PROPERTY LOCATION: Subdivision w/phase or section: Pattons Point Lot #: 90 Lot Acreage: .35

February 9, 2010

Re: Status of Improvement Permit Application # 07-5-17429 RR

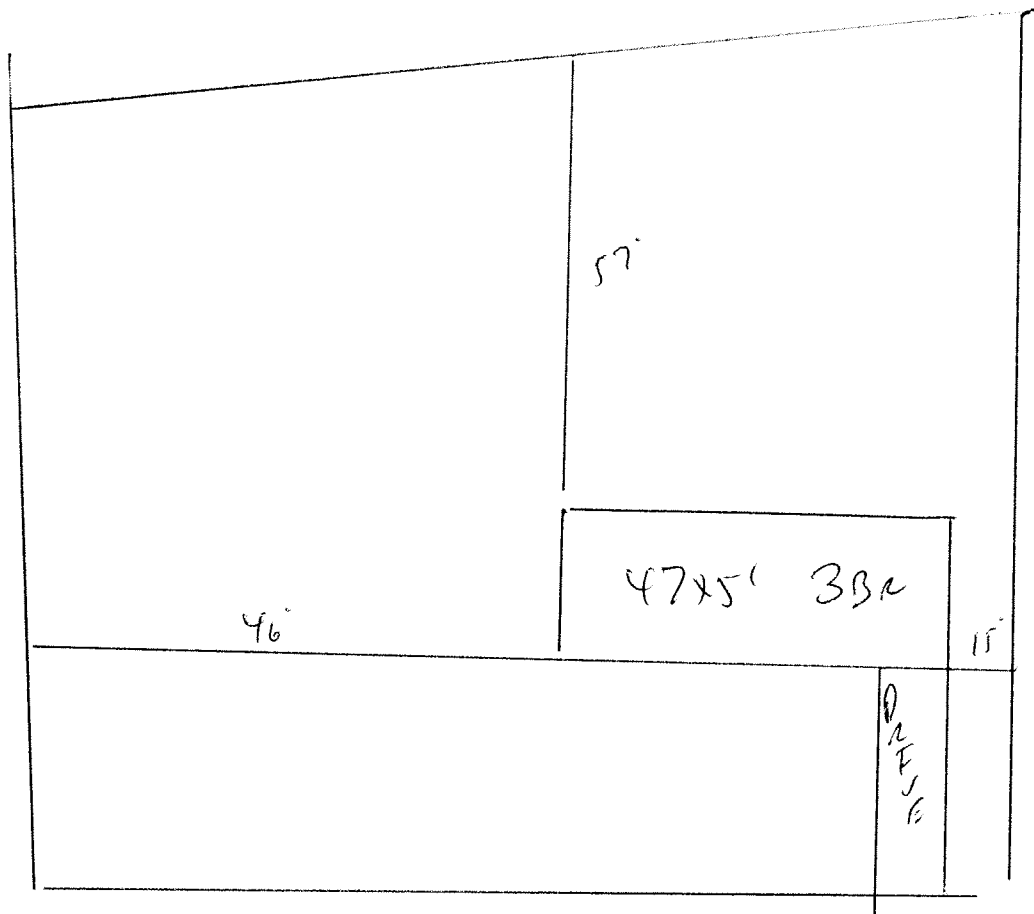
1. Use pink flags to mark property lines and irons that are set by surveyor need to be visible (\$25.00 fee incurred)
2. Use orange flags to mark house corners (\$25.00 fee incurred)
3. Directions not clear to property (\$25.00 fee incurred)
4. Property needs only brush or vegetation removed
5. Backhoe pits required
6. **Other- You have two options on this lot- move the house as shown on original permit or move house as shown on next sheet. Choose one option and submit new plan to Central Permitting.**
